TfNSW Reference: SYD21/00462/17

DPE Reference: SSD-17647189

**RESPONSE TO TFNSW ADDITIONAL INFORMATION REQUEST
884 - 928 MAMRE ROAD, KEMPS CREEK**

884 Mamre Rd - 3rd Review			
RMS Registration Number	SYD21/00462		
Client Registration Number			
Design Stage	Strategic Design		
Dated			
Design Review			
Review Date	12/05/2023

**Annexure 1 – LILO Strategic Design 2021\_19\_SD\_0001\_SK00014 Issue B**

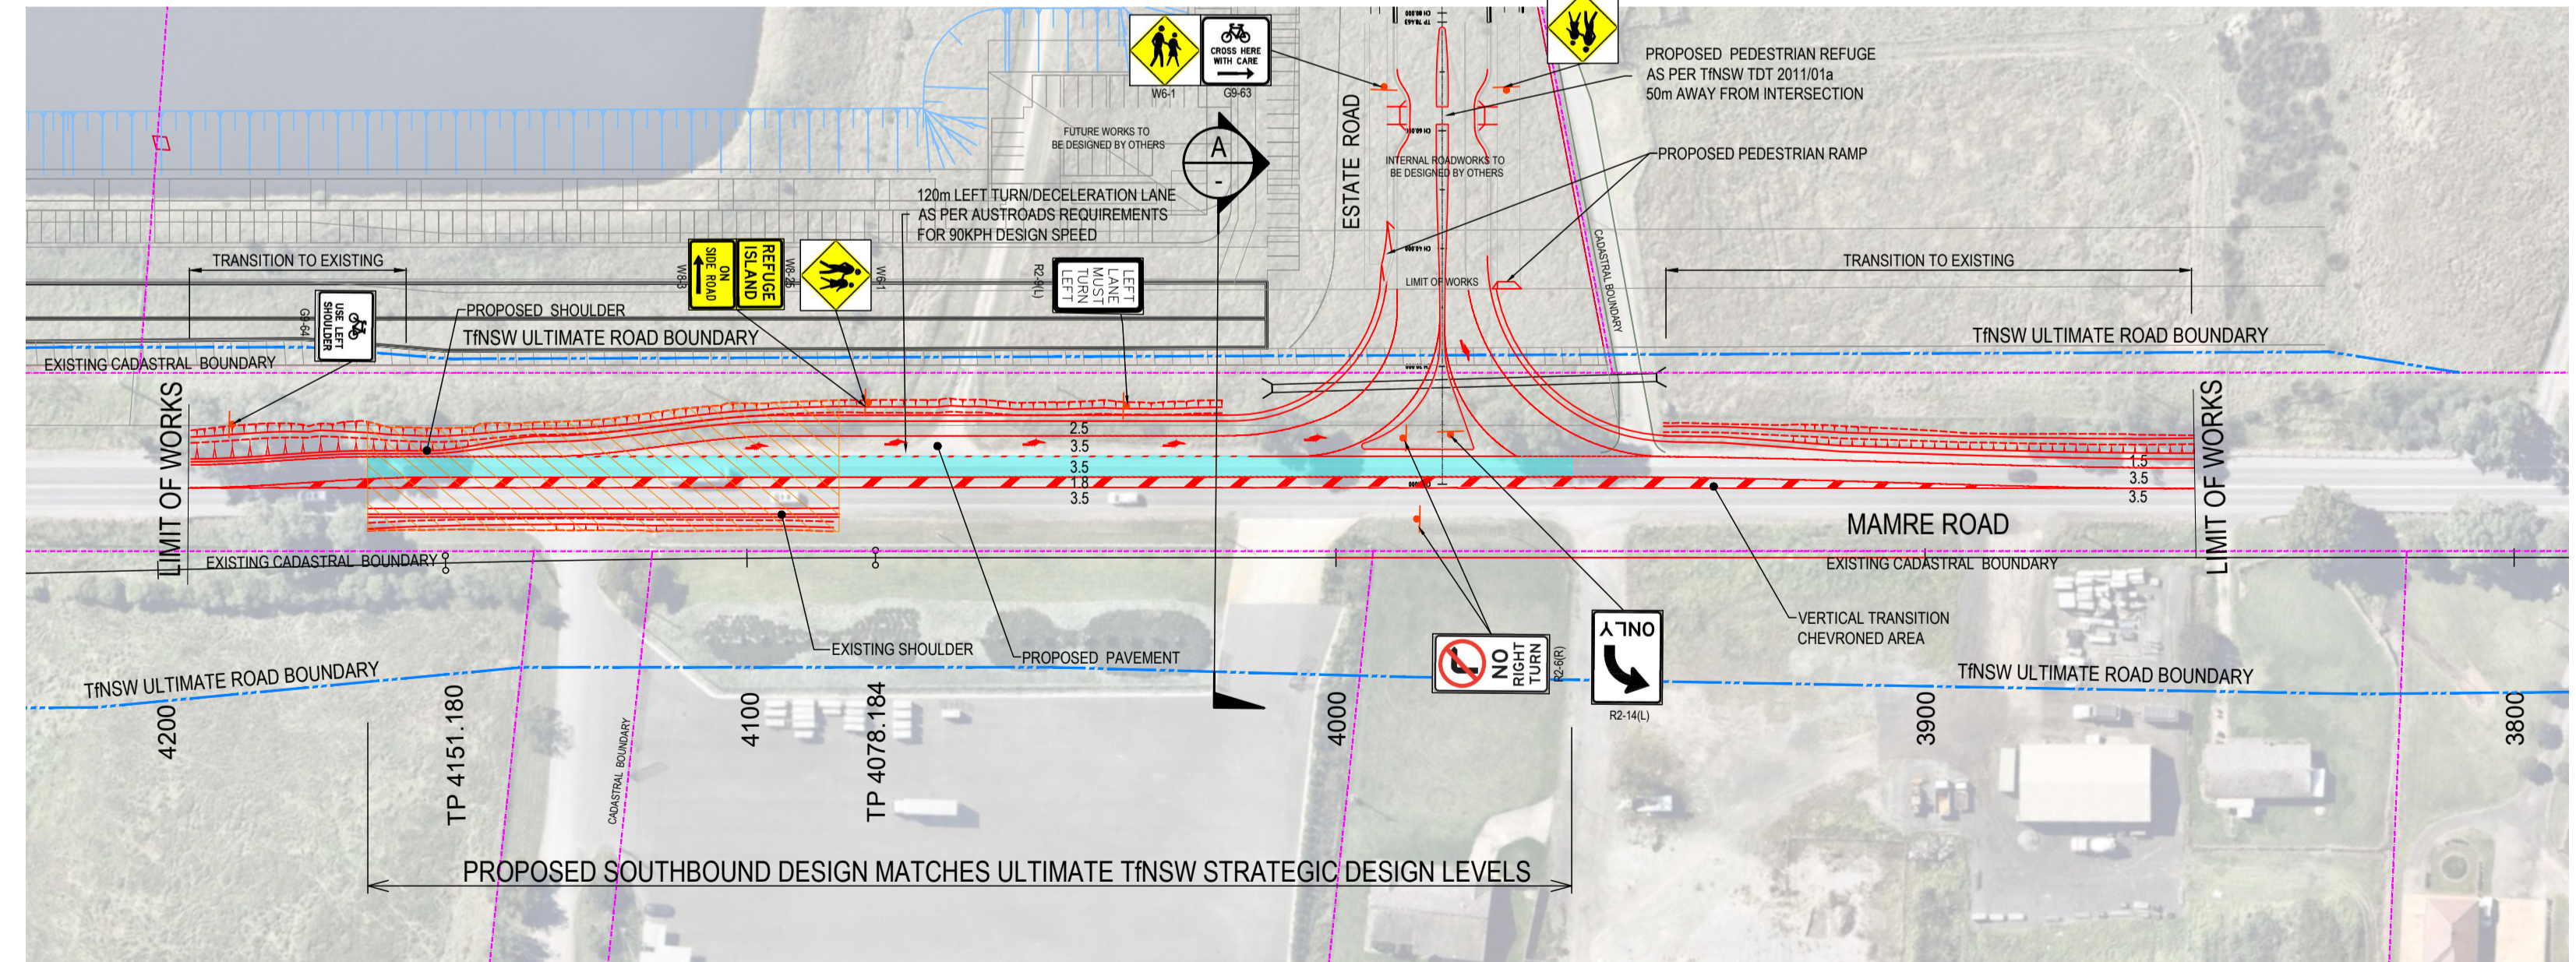
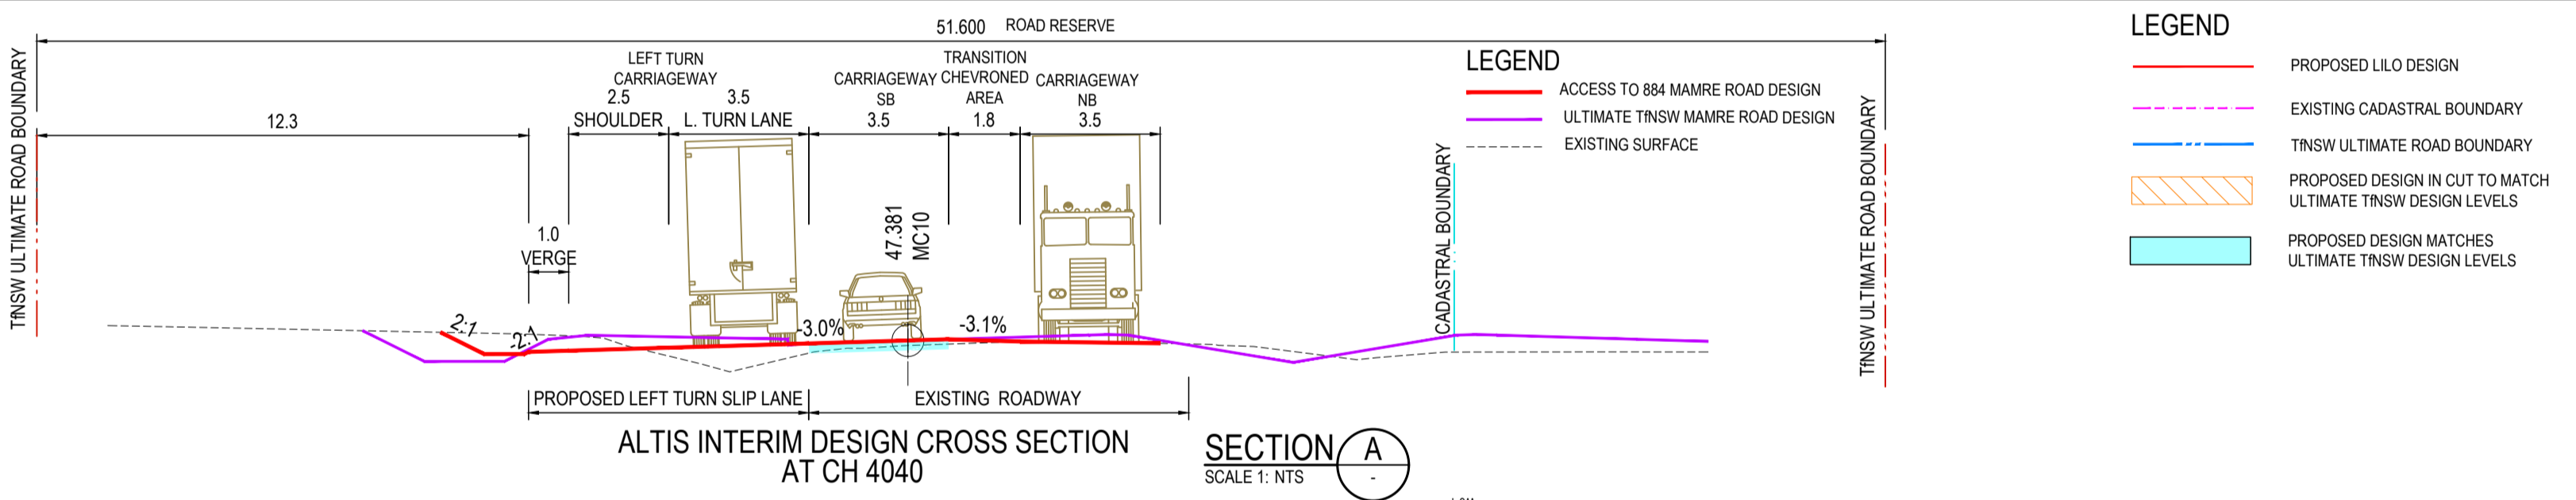
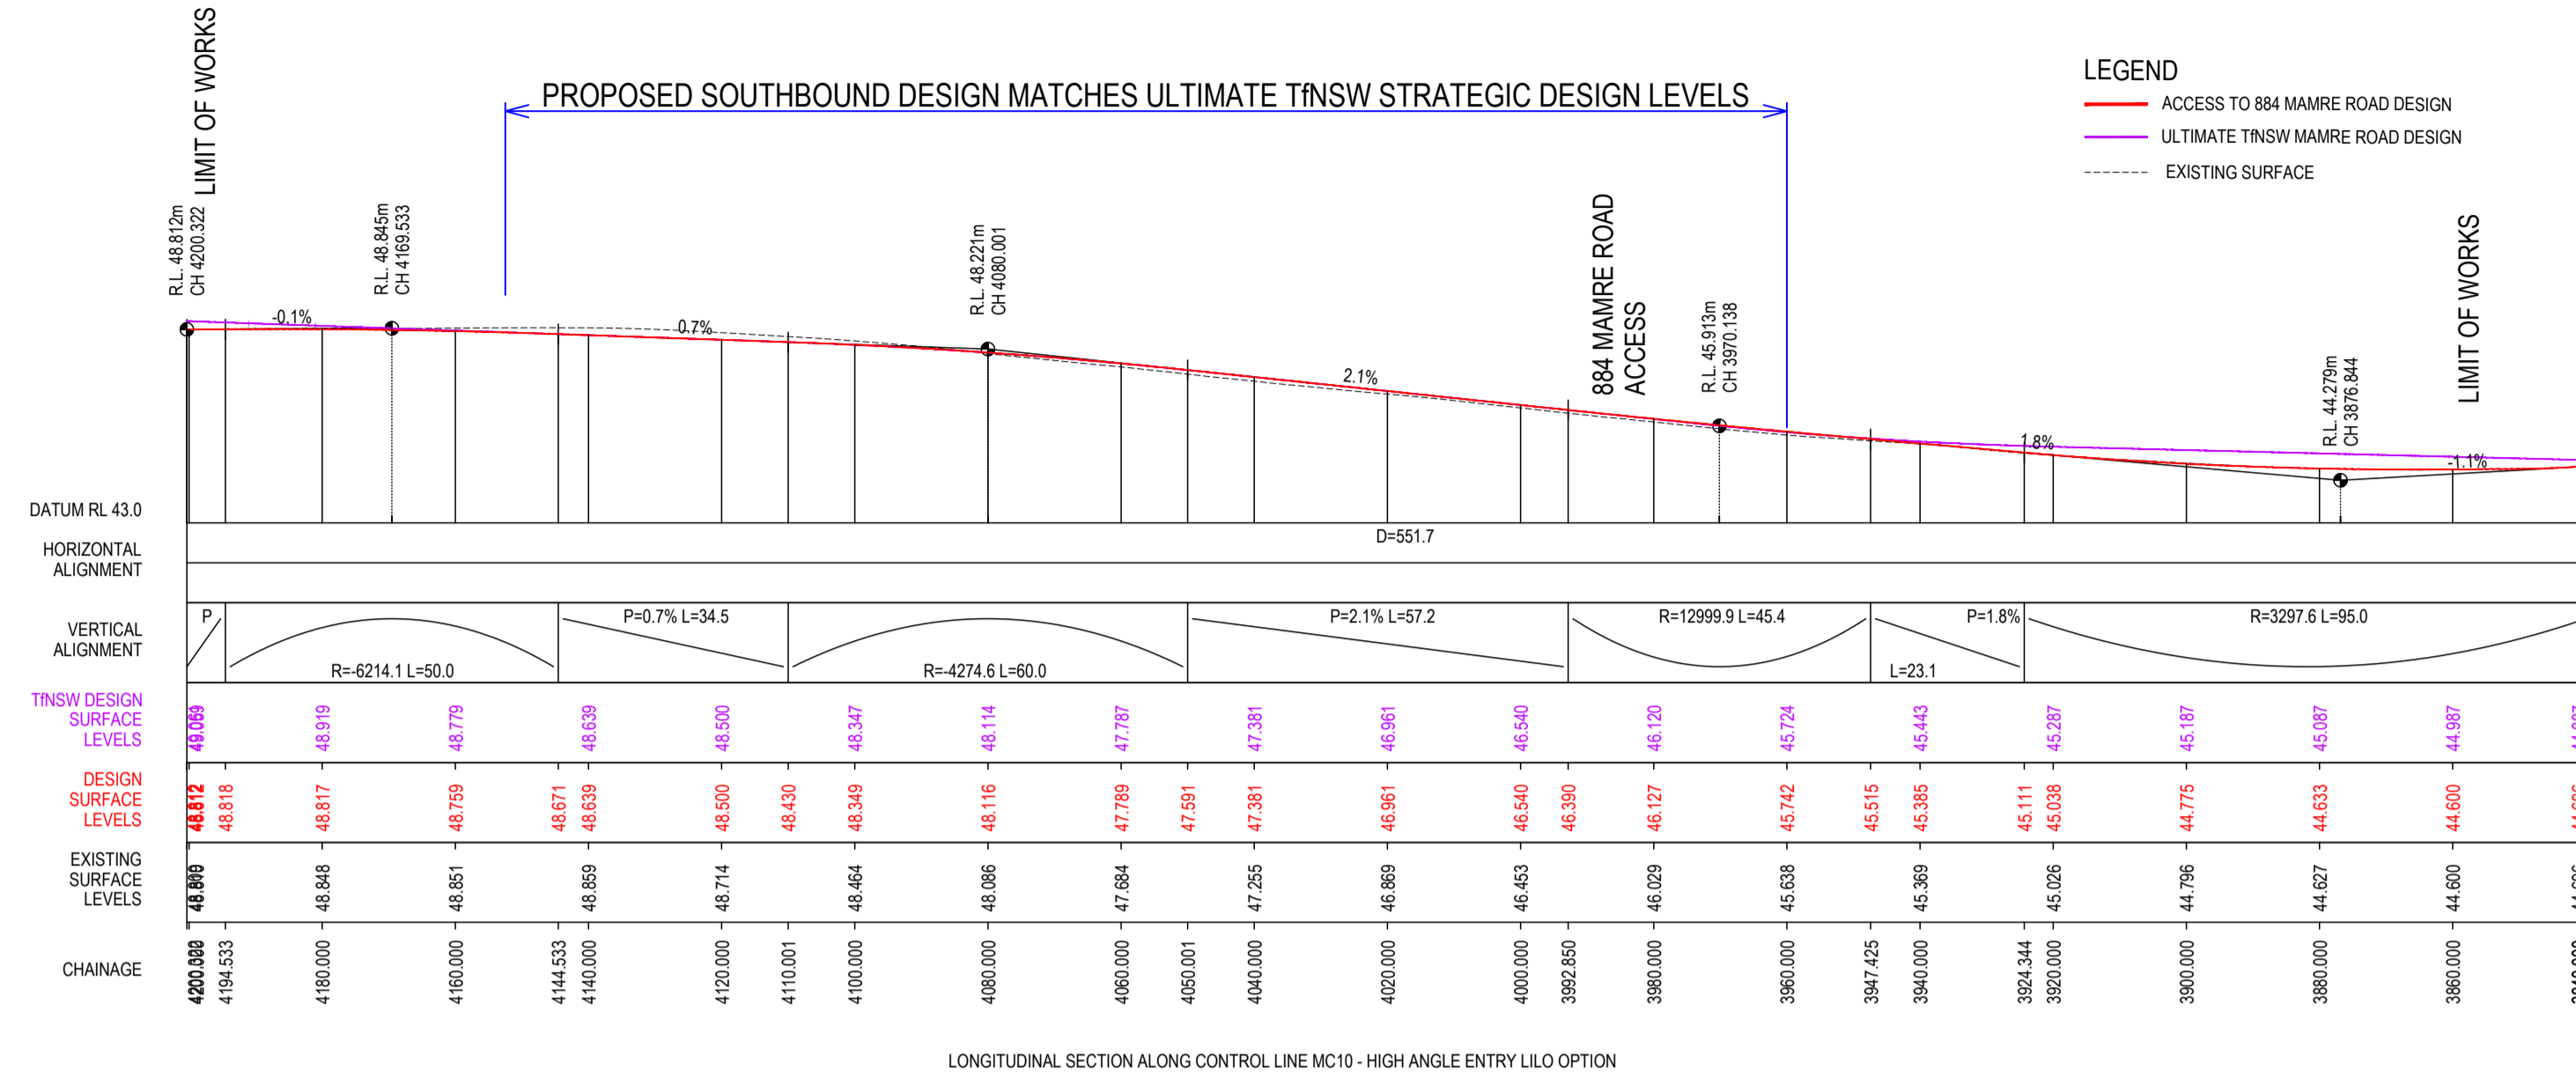
3	6/2/23	MRUS2 project team	Consider the safety of access points (driveways) with acceleration lane to the south	29/03/2023	TfNSW has provided instruction to remove the acceleration lane as shown in strategic design drawing (2021_19_SD_0001_SK00014 Issue B). The acceleration lane will only be constructed once the southern property is developed or residents vacate.	12/05/2023	Noted and agreed. Comment can be closed.
4	6/2/23	MRUS2 project team	Minimise sacrificial works – show planned permanent / sacrificial works on the drawings	29/03/2023	The proposed strategic design has considered the Ultimate TfNSW Mamre Road Design. The strategic design drawing (2021_19_SD_0001_SK00014 Issue B) shows highlighted in like blue the proposed southbound carriageway matching the Ultimate TfNSW design level including at the intersection. This plan is provided in Annexure 1 There are no works that are considered sacrificial. Areas that need to be reworked are marked as transition areas in the drawing. We believe this approach is the most appropriate considering the Ultimate Mamre Road levels are not finalized.	12/05/2023	TfNSW is currently progressing the Review / Refinement of Mamre Road Upgrade Strategic Design. This will include changes to the horizontal and vertical geometry at this LILO location. An example of change is the adoption of a constant 17.7m between northbound and southbound control lines, which will result in 5.5m widening of the median. LILO design will need to ensure enough space between left turn carriageway (on entry side) and proposed cadastral boundary, including any shared path / verge / drainage requirements. Updated geometry is expected to be available in July 2023. If needed in a more timely manner, MU Group and TfNSW can work collaboratively to address this item. This comment will remain open until the above items are addressed and closed-out in subsequent design stages.

7	6/2/23	MRUS2 project team	Road levels to be consistent with TfNSW Strategic Design for Mamre Road upgrade. At the LILO the proposed road will be 500mm higher than existing.	29/03/2023	The proposed strategic design drawing (2021_19_SD_0001_SK00014 Issue B) shows highlighted in light blue the proposed southbound carriageway matching the Ultimate TfNSW Strategic Design level including at the intersection. This plan is provided in Annexure 1 As shown on the long section, the intersection is at approximately CH3980 and the level difference between the TfNSW Strategic Design and existing level is 91mm.	12/05/2023	Per TfNSW's 2017 Strategic Design (DS2015-003043_Issue C), there is (approx.) 550mm difference between design and existing levels at CH3980 along control line MC01 (northbound, between travel lane and inside shoulder / verge). Additionally, we note MU Group have amended the vertical alignment further south of the LILO access point, e.g. more pronounced crest and sag points. Please provide reasoning behind this deviation from TfNSW Strategic Design (2017). As noted in Item 4 above there will be changes to the horizontal and vertical geometry at this LILO location as part of the Strategic Design Review / Refinement. This comment will remain open until the above items are addressed and closed-out in subsequent design stages.
